RIX'S CREEK MINE EXTENSION PROJECT, SSD 6300
EPA'S RECOMMENDED CONDITIONS OF APPROVAL

I refer to your email to the Environment Protection Authority (EPA), dated 2 November 2015, seeking the EPA's comments on the Rix's Creek Mine Extension Project, SSD 6300 (the project). The EPA has reviewed the project as detailed in the report titled '*Rix's Creek Mine – Continuation of Mining Project, Environmental Impact Statement: 26 October 2015*' (EIS) Volumes 1 – 5, prepared by Aecom Australia Pty Ltd.

Figure 2: Sensitive receptor locations assessed in the AQA

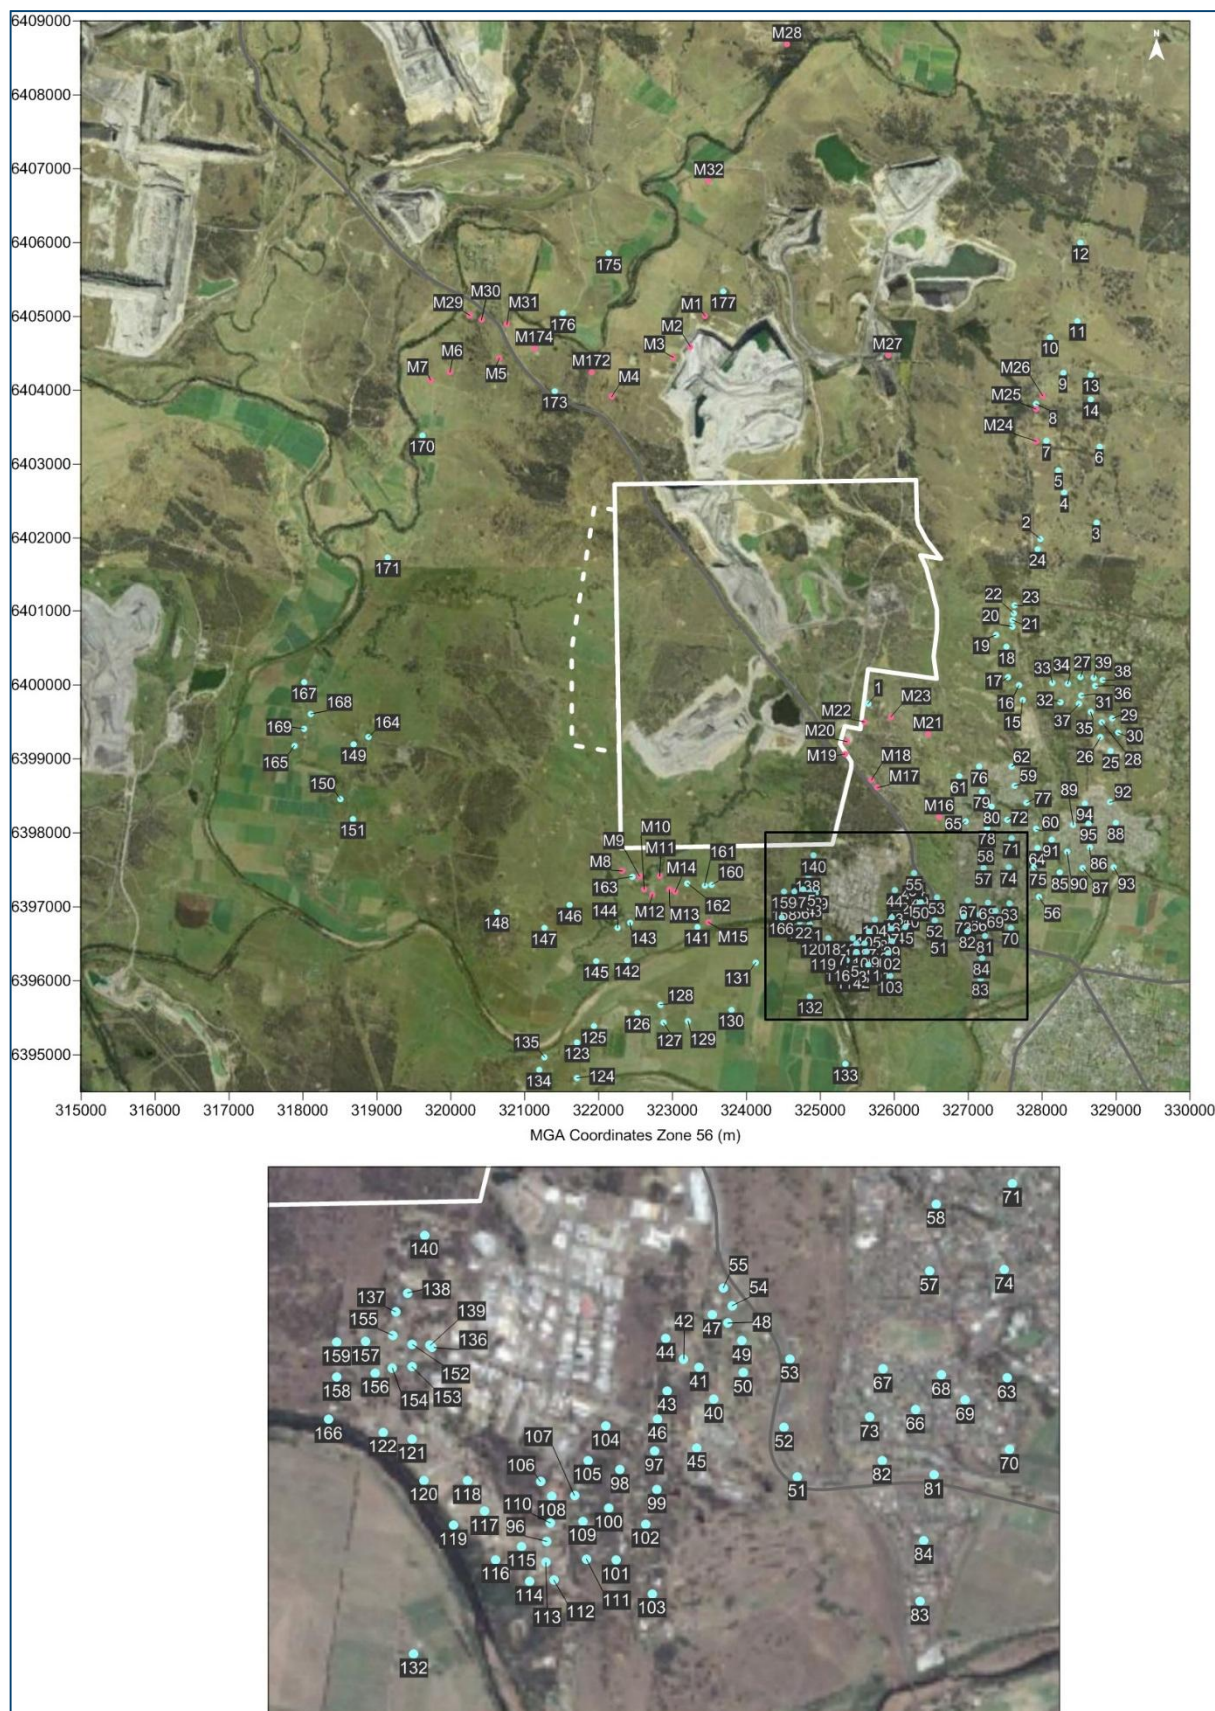
Maison Dieu lies behind an arc from receptor R140 and M18. In this sense R140 is closer to the proposed extension. However, both R140 and M18 are assessed as exceeding air quality criteria. It is therefore possible that other receptors in the area could also exceed, especially given the prevalence of wind from the west-north-west. The EPA requires assessment of additional receptors in this area to identify all potentially affected properties.

Country Acres Caravan Park at 58 Maison Dieu Road lies to the south-west of the proposed pit expansion and within 500 metres. It does not appear to have been assessed as a receptor. Maitland Diesel Service is located on Rix's Creek Lane and also does not appear to have been assessed as a receptor. The EPA requires the potential impacts at these receptors to be assessed.
